I am commenting on the above application from an arboricultural aspect.

Site – Tapper Farm - Bodicote

Proposal – to demolish existing buildings and building 46 dwellings

**Plates 13 & 14:** further cankers and structural defects noted within the crown of T8.

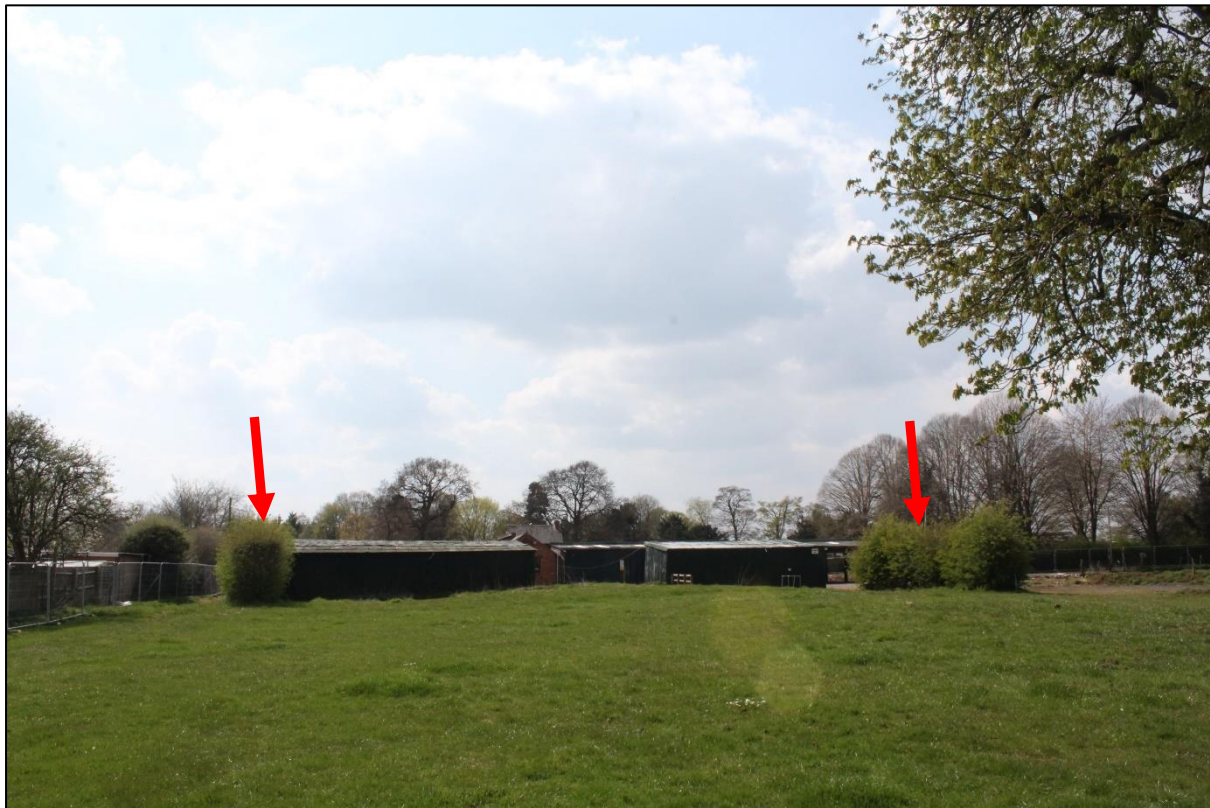
12. The plan below illustrates the required RPAs (in red) to allow for future growth of the trees. Also it is not possible to ensure the TPO tree T8 is properly protected in the long term being located in the rear of 4 separate gardens. It should be in an open space. The RPA of these protected open space trees should be protected by railings to ensure vehicles do not use those areas to cause compaction.

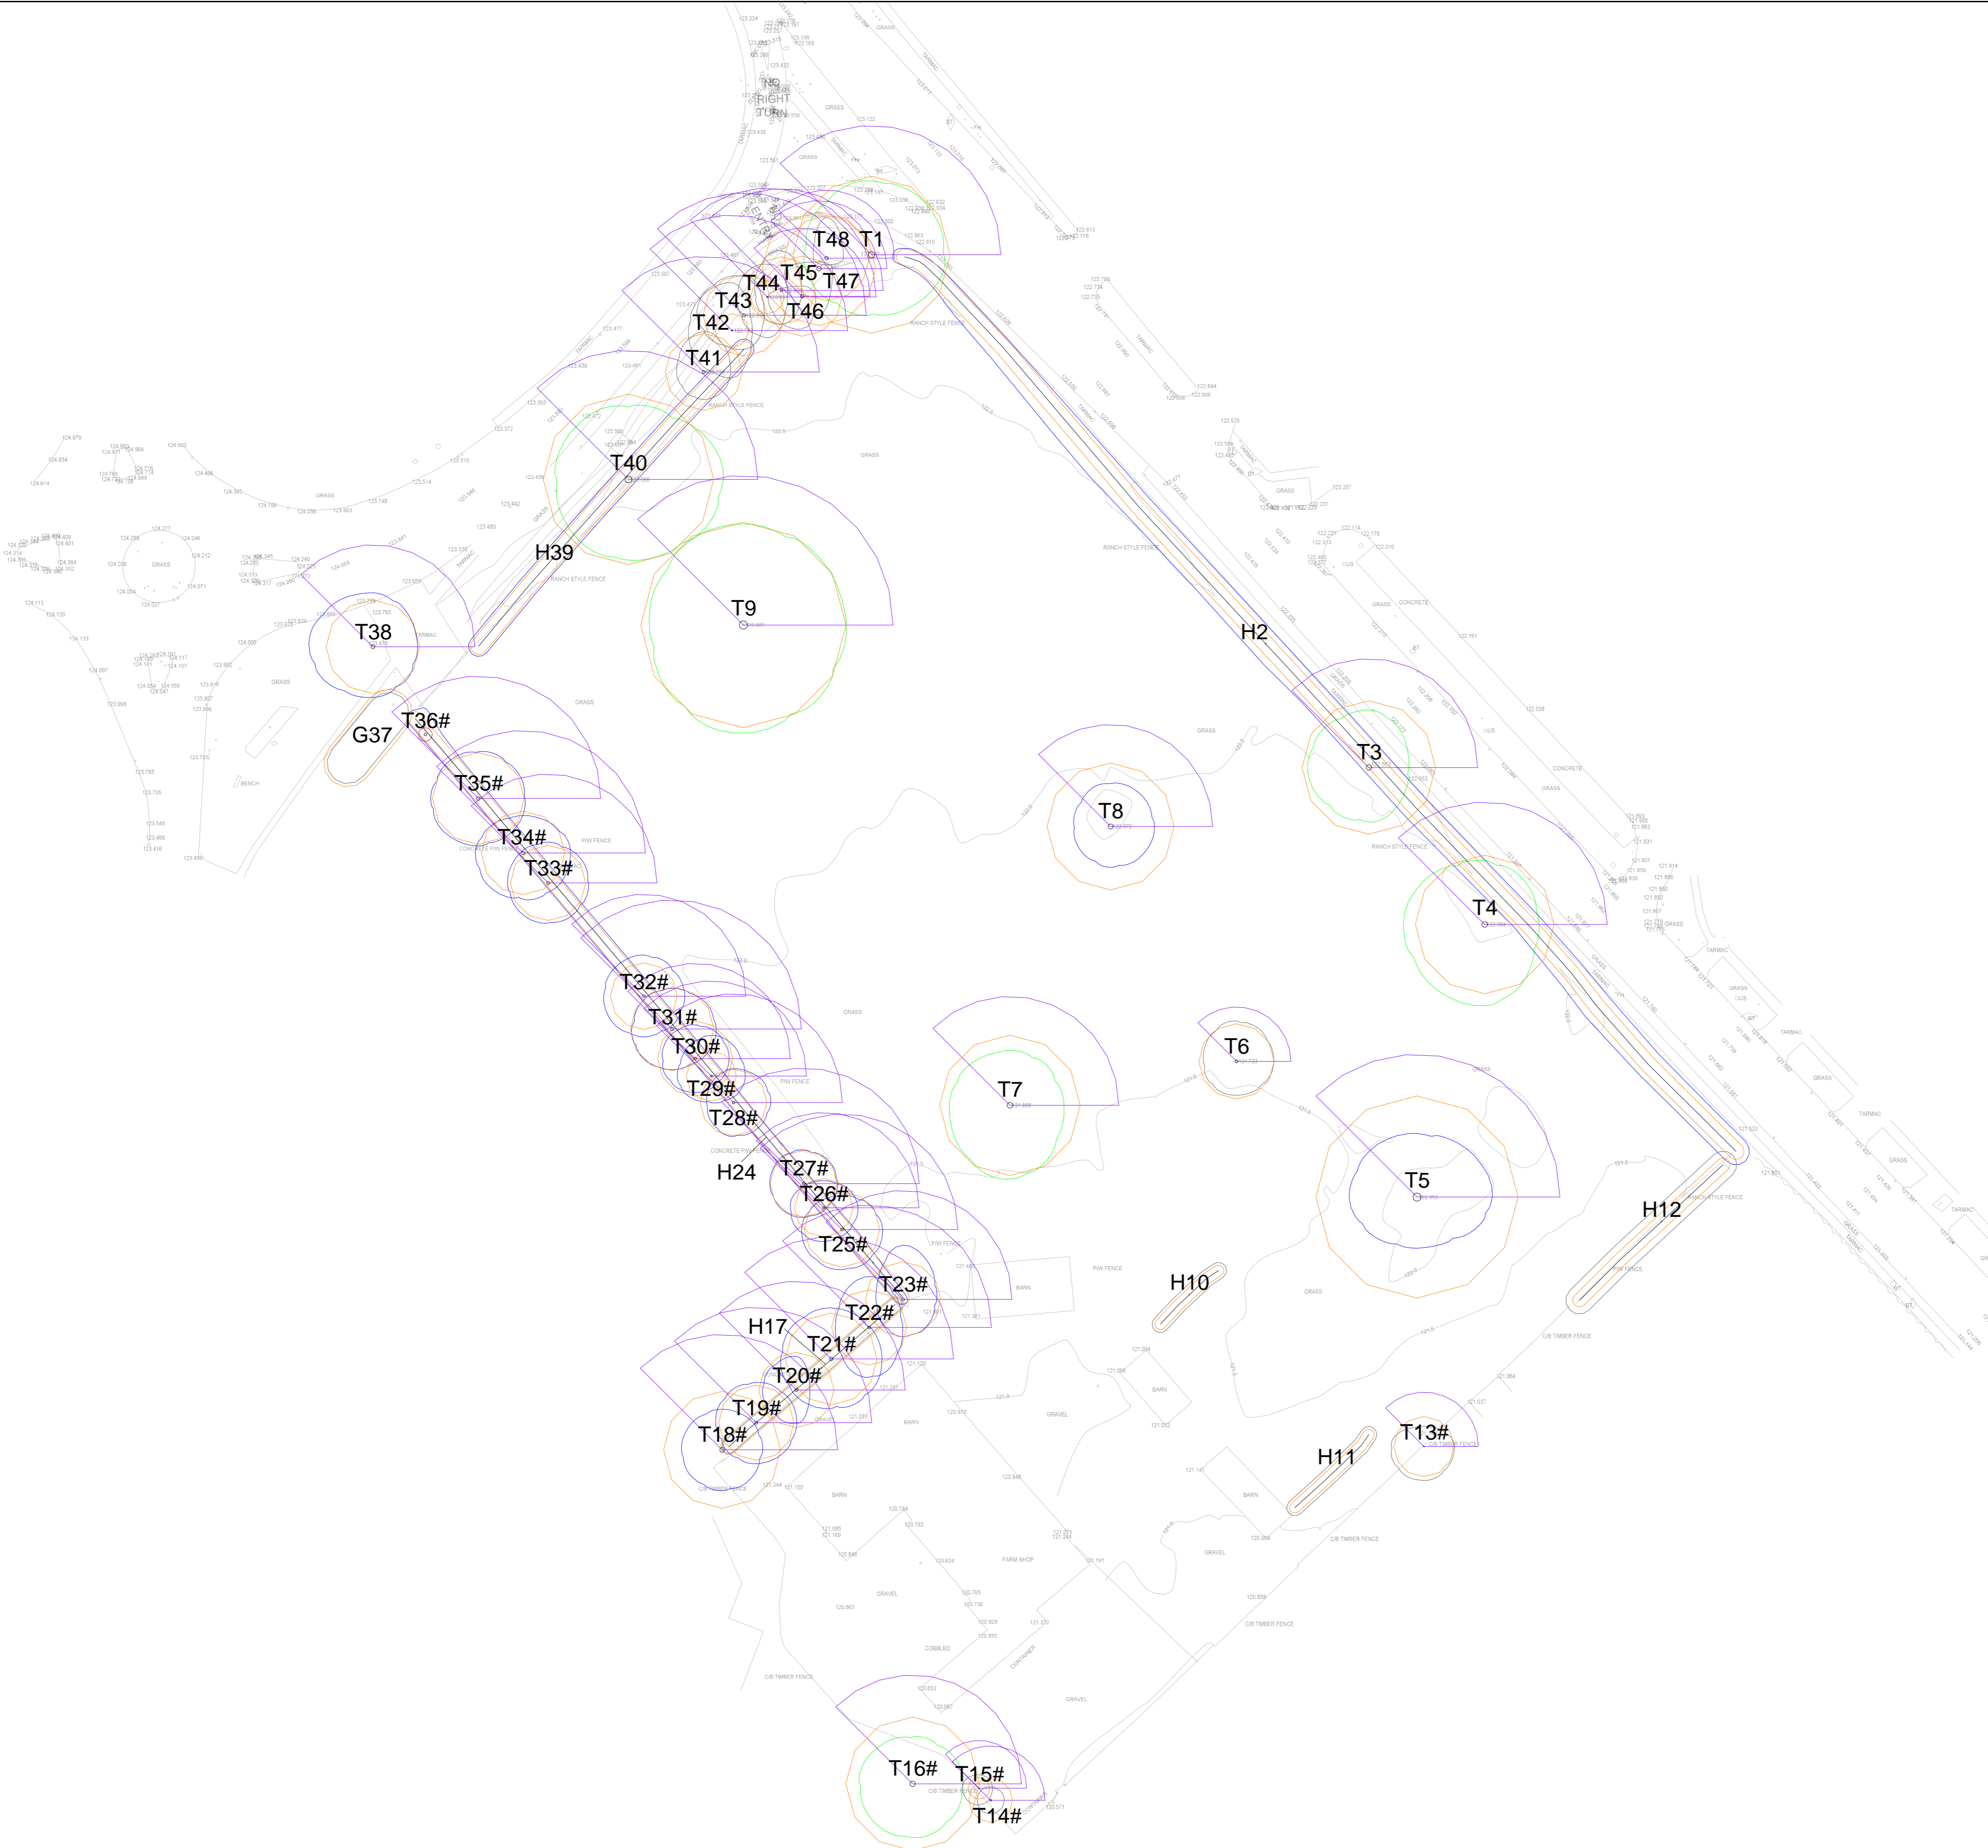
5. The Root Protection Area (RPA) parameters applied to the proposed layout limits the future development of the trees. The maximum limit of 15 meters RPA should have been applied to allow for future growth of the protected trees.

6. All RPAs have been applied as circles and have not allowed for pre-existing site conditions, ie buildings and roads. As per clause 4.6.2 of BS5837 :

This reflects mainly to the oak tree T3, beech trees T4 and T40.

11. Severe pruning is proposed to the category A beech tree T4 due to the encroachment of the proposed new road. This is not acceptable for a tree of this significance.

## Tree Protection Plan

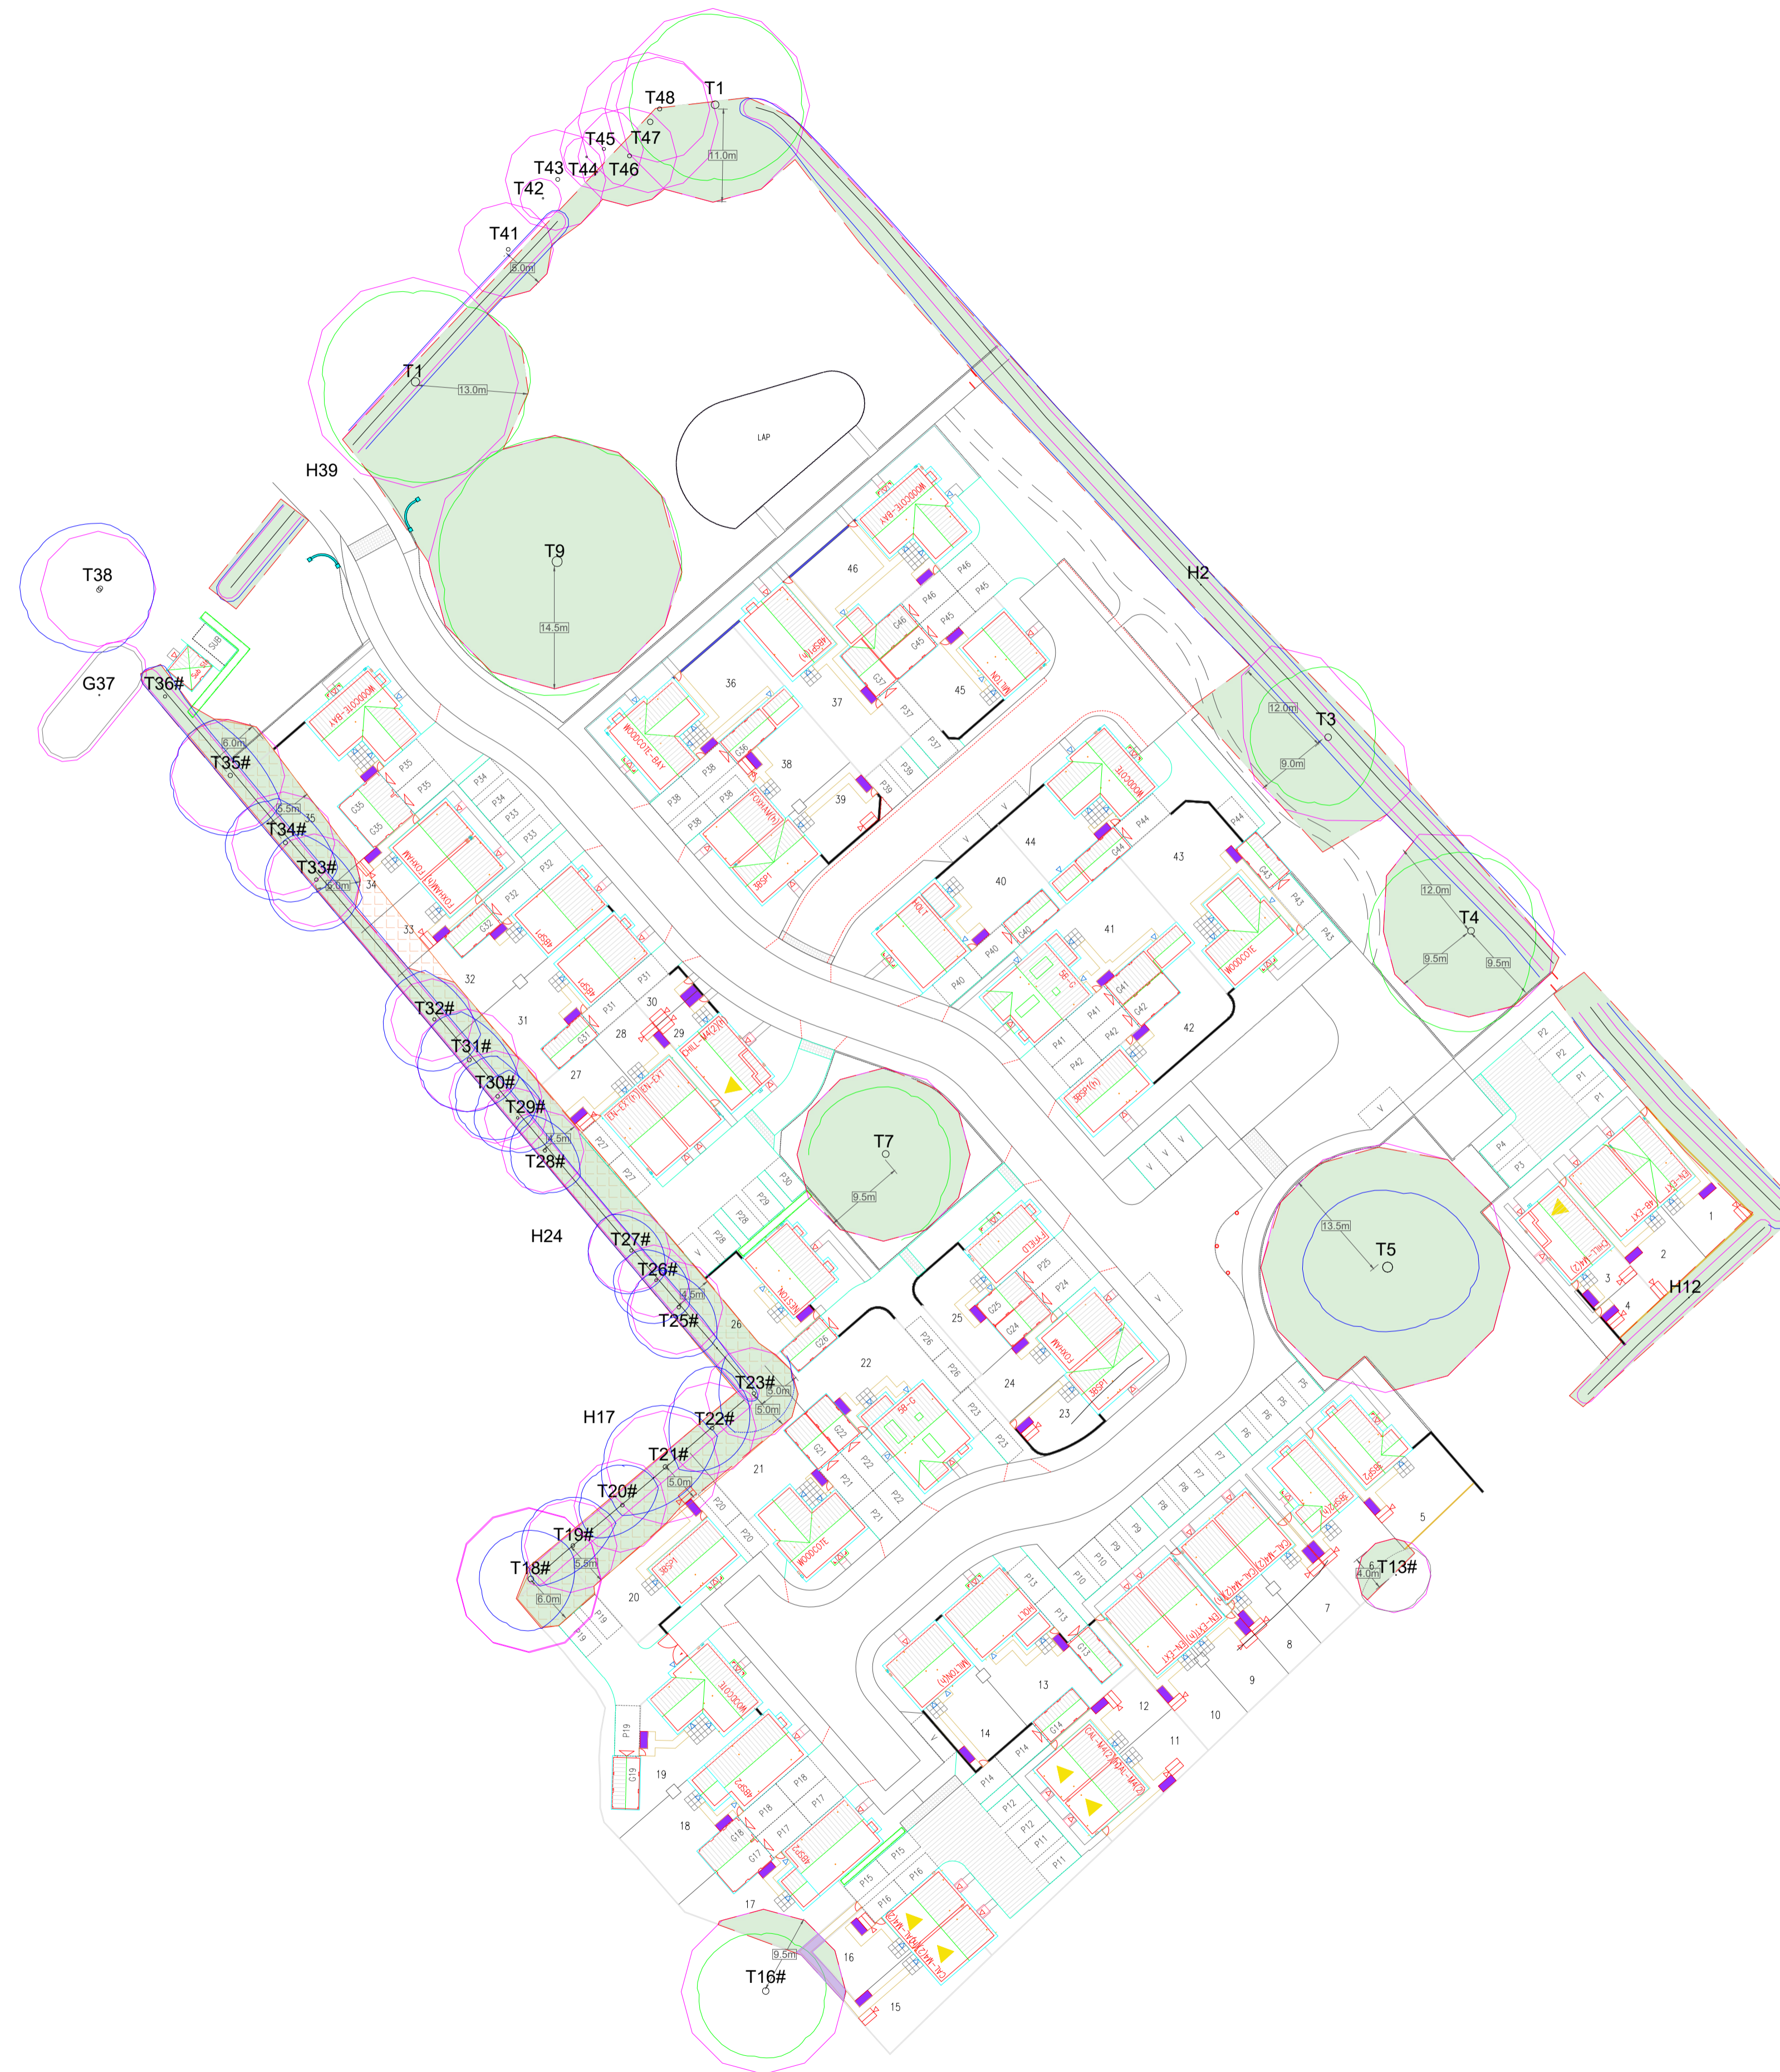
13. It is important that the soft landscape design is carried out in conjunction with the Tree Protection Plan and Arboriculturist. There is no point in installing a no dig path and then digging into the ground to plant a multitude of shrubs with the RPA.
